PRE-HEARING STAFF ANALYSIS

Rezoning Petition No. 2008-074

Petitioner: Public Library of Charlotte & Mecklenburg County

Request: B-1SCD, business shopping center to B-1(CD), neighborhood business conditional.

PRELIMINARY
SITE PLAN

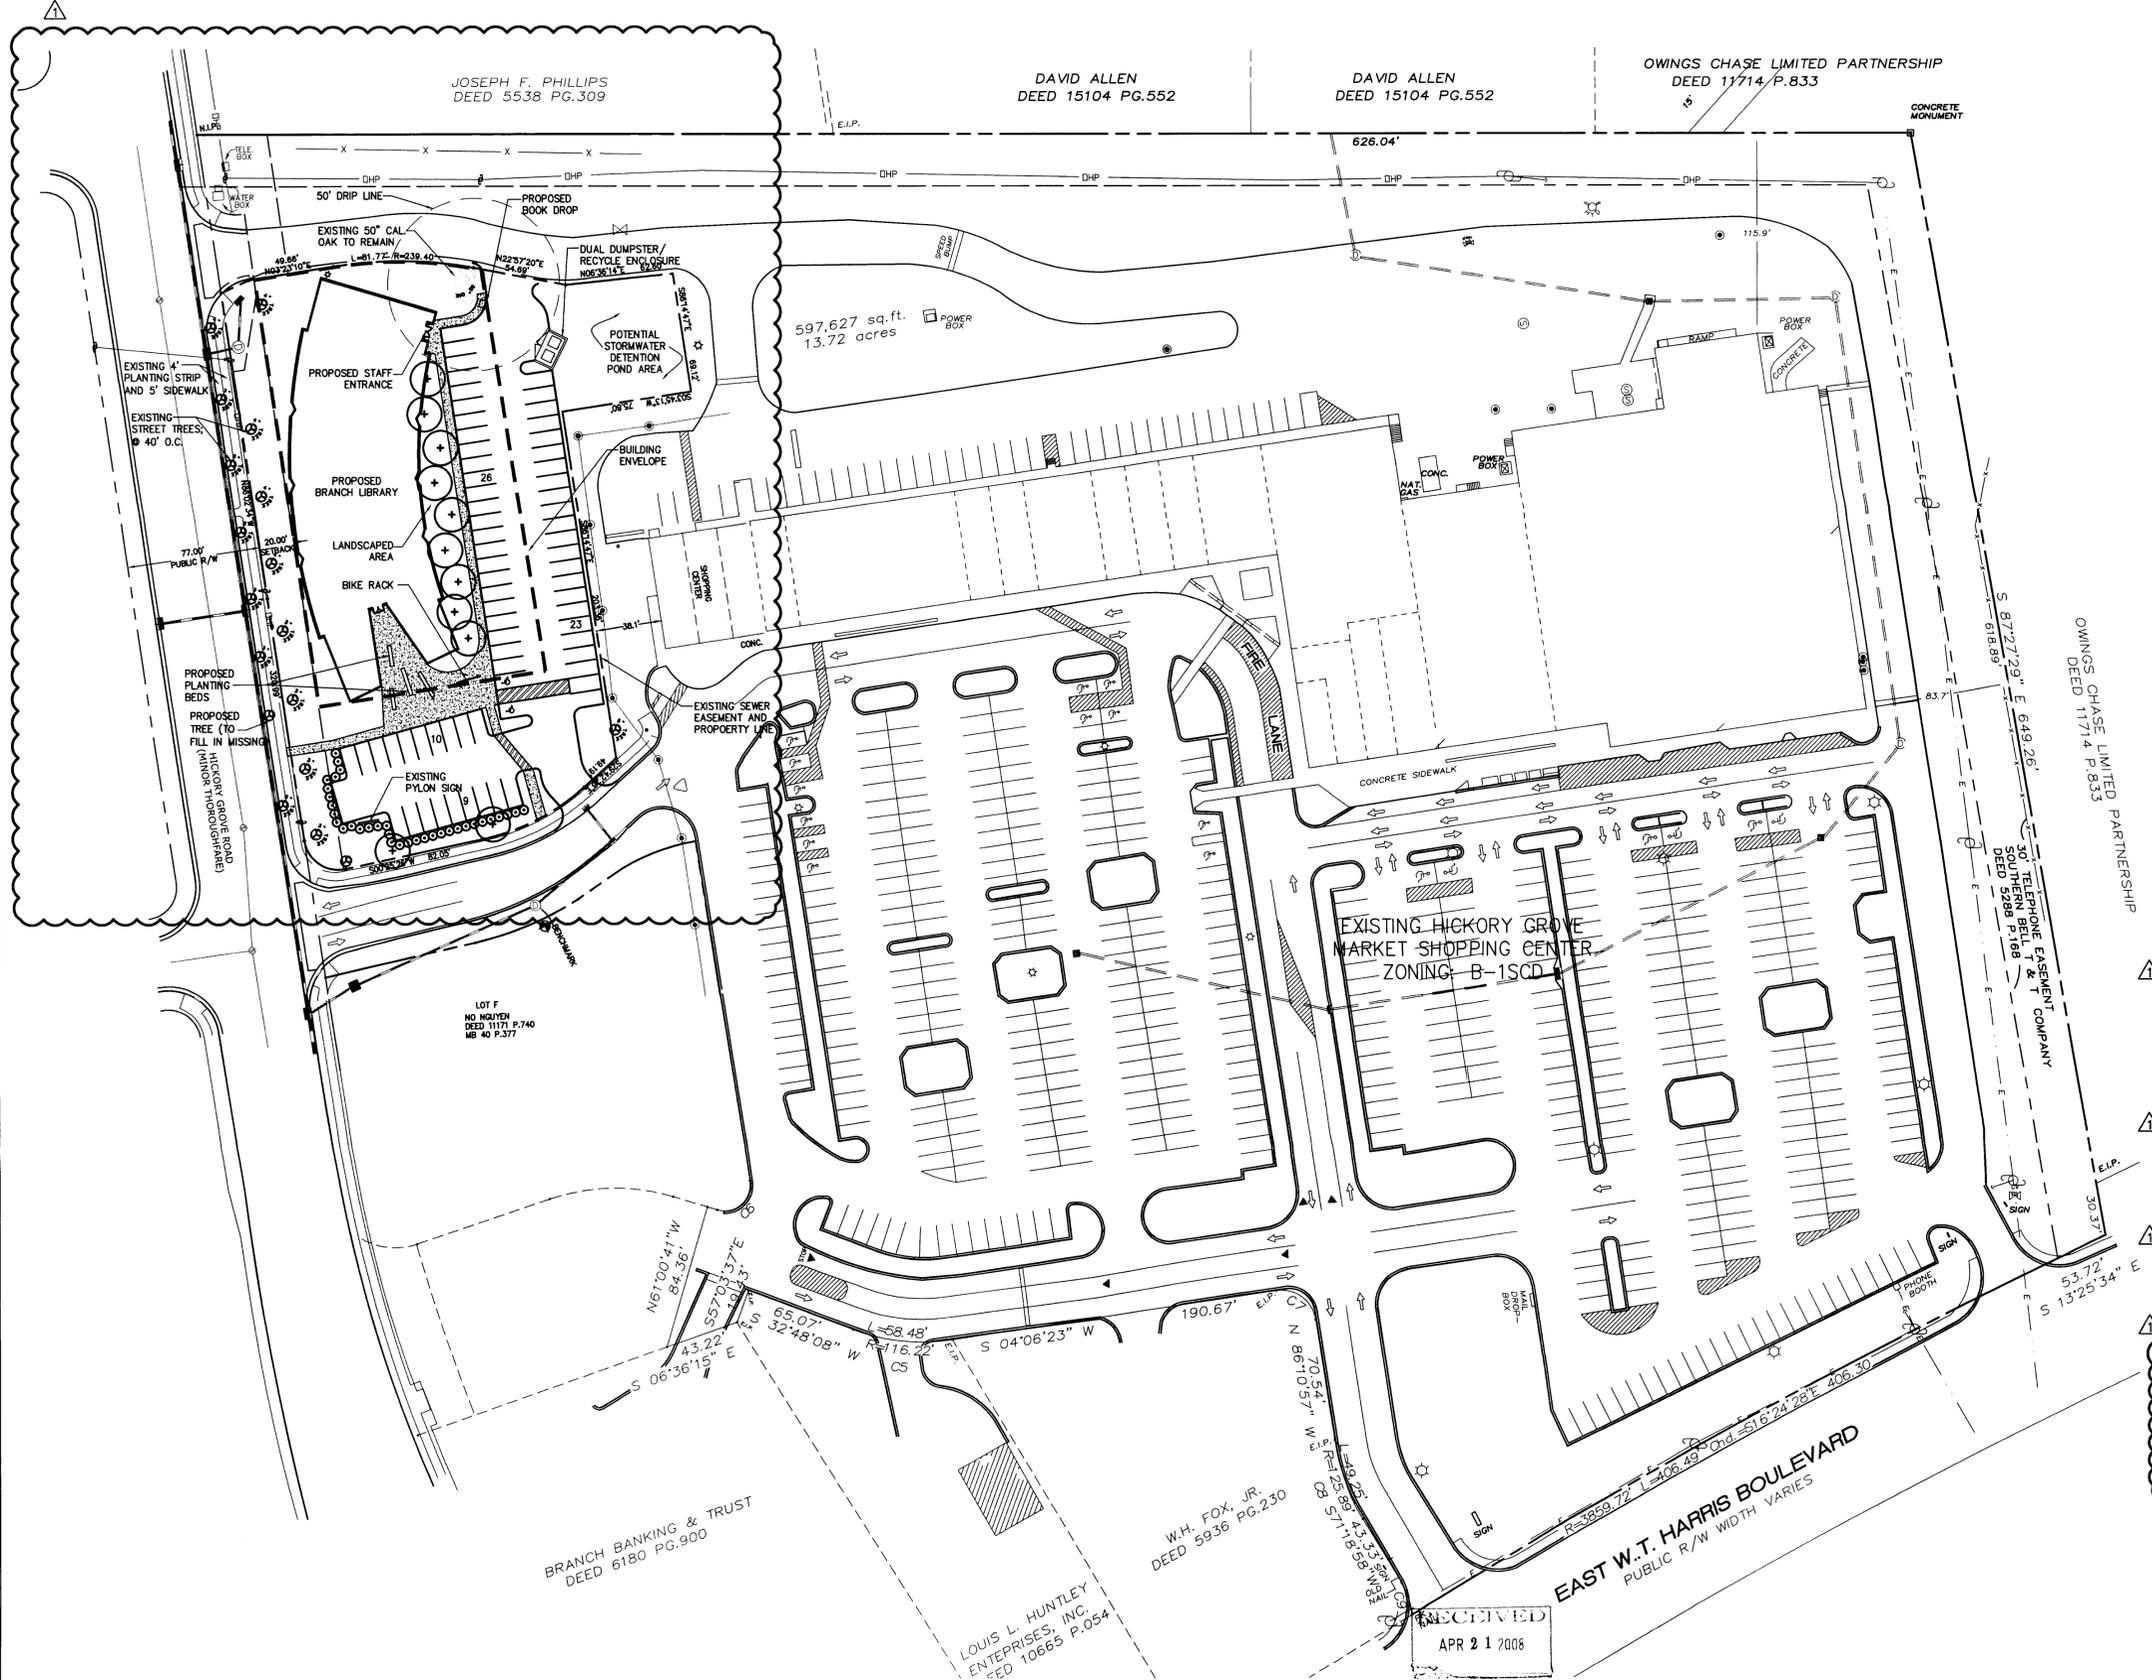
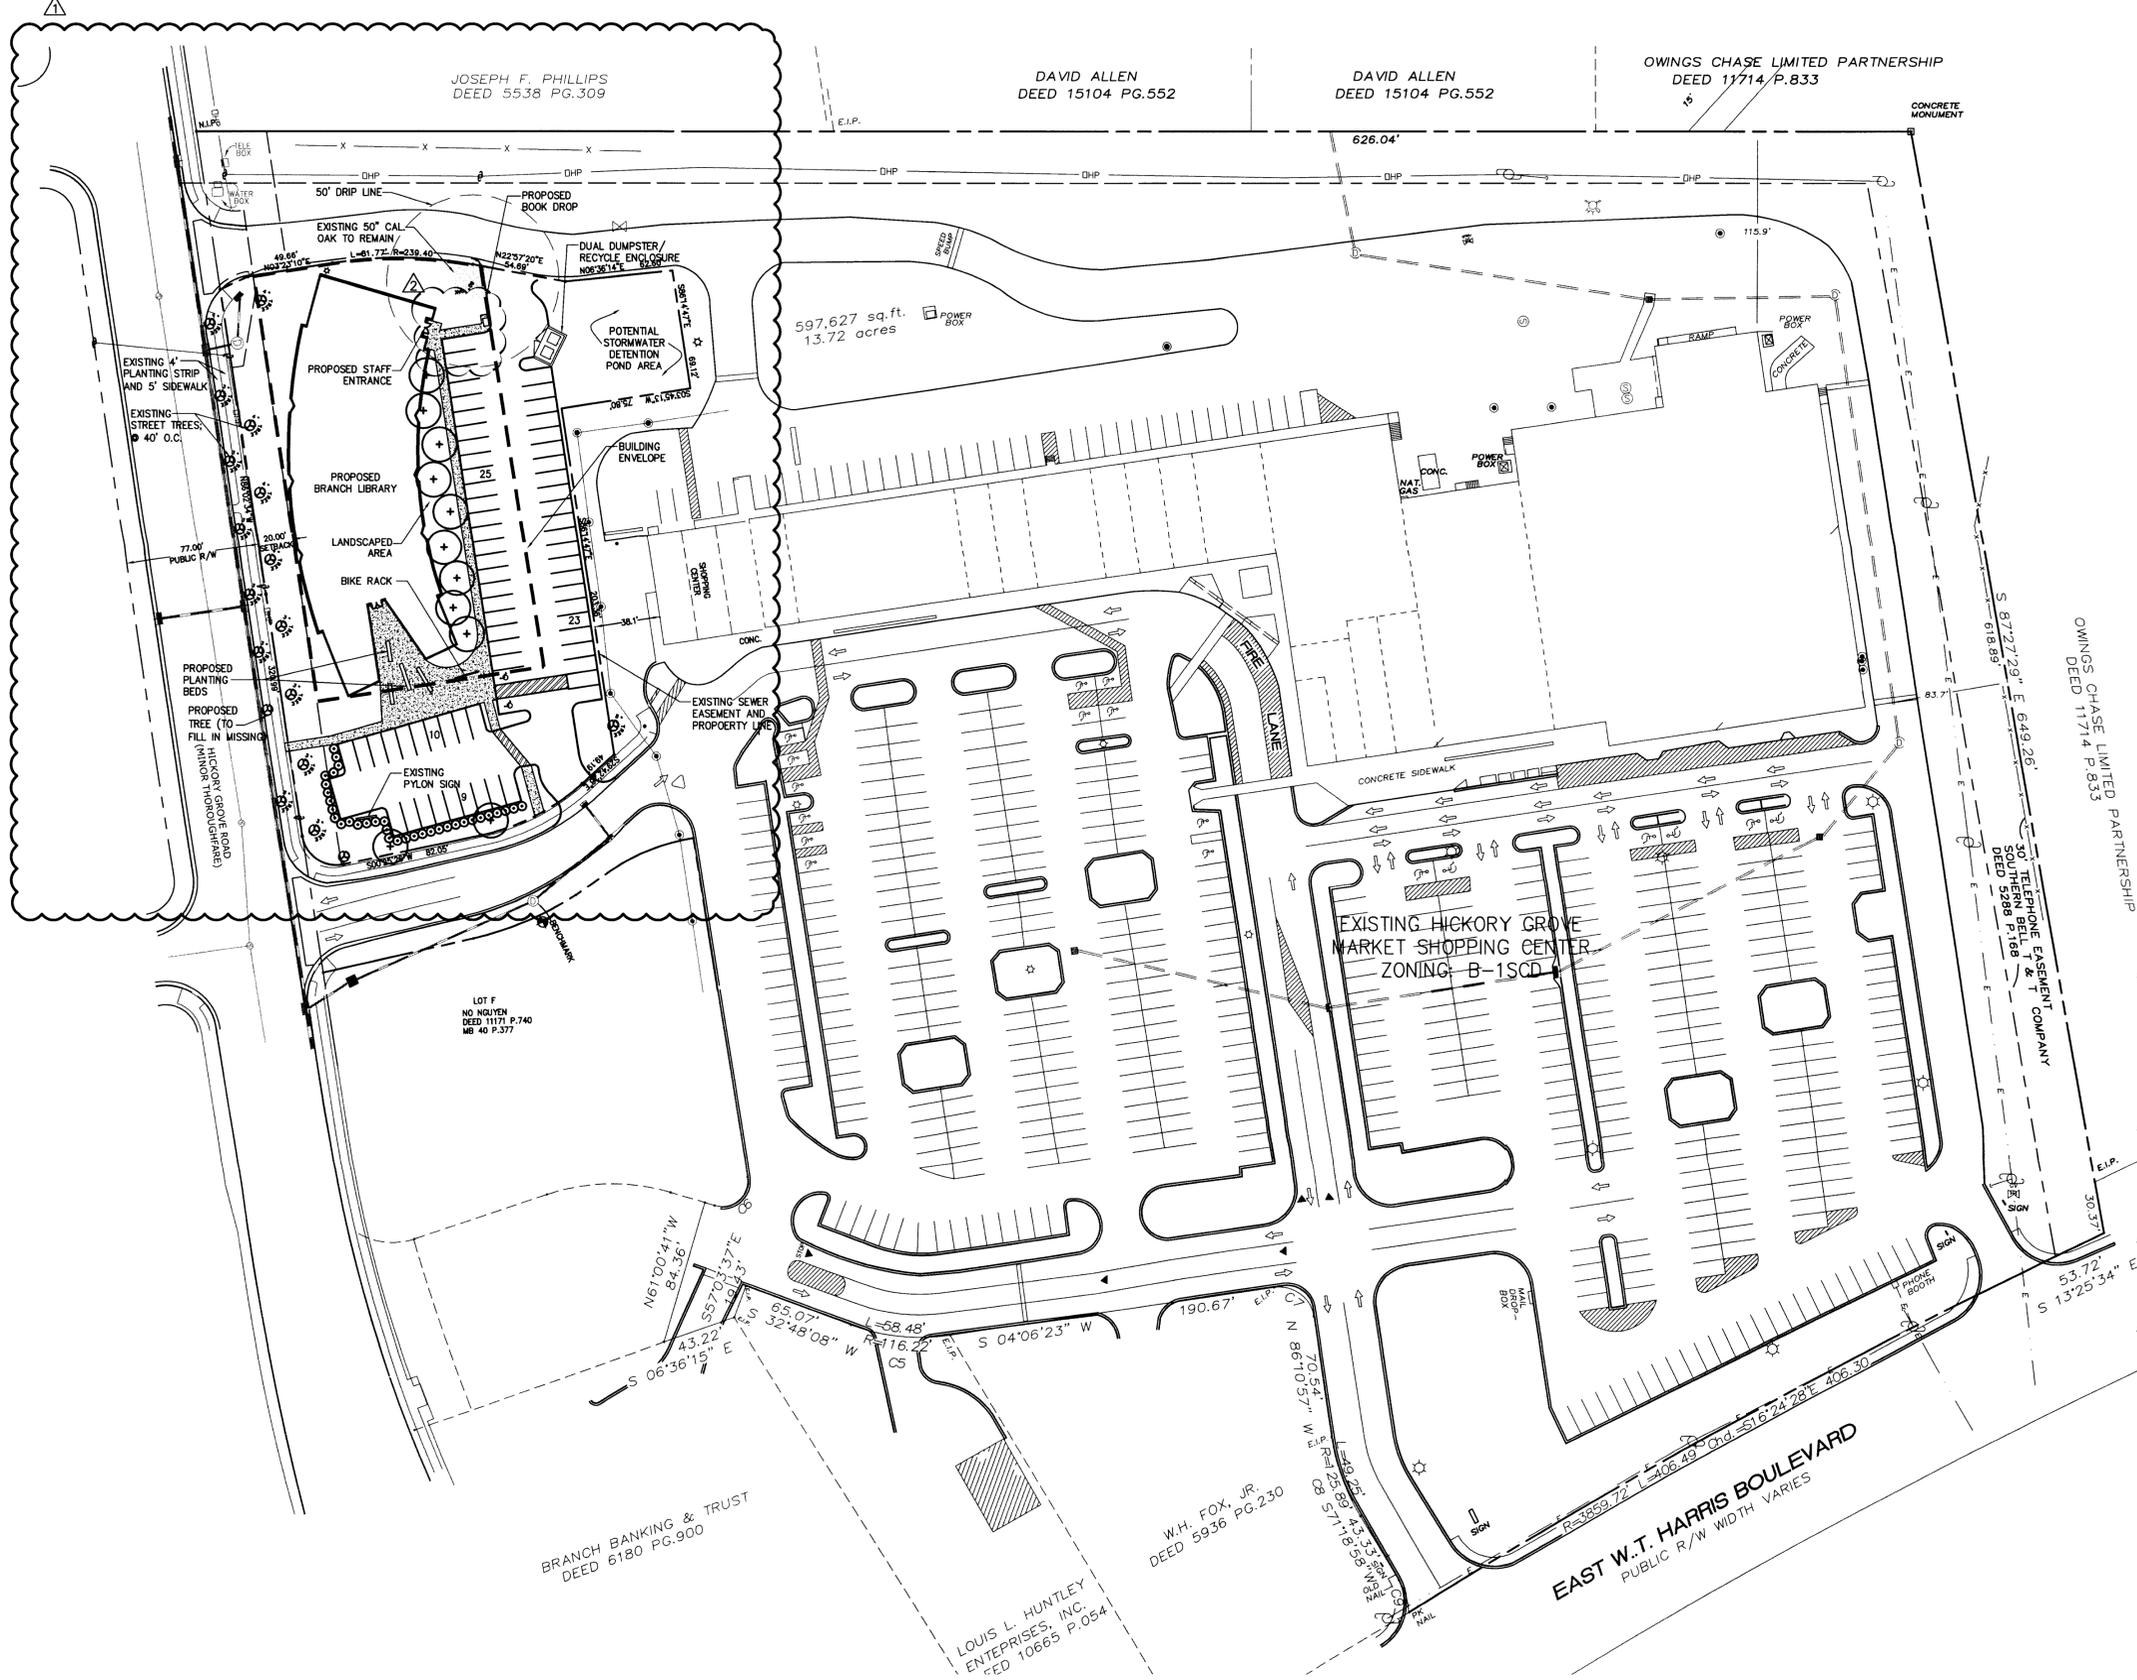
Site plan. The following site plan issues are still outstanding:

- Book drop location is too close to entrance; move location to provide stacking.
- The petitioner should add note to address LUESA's comments.
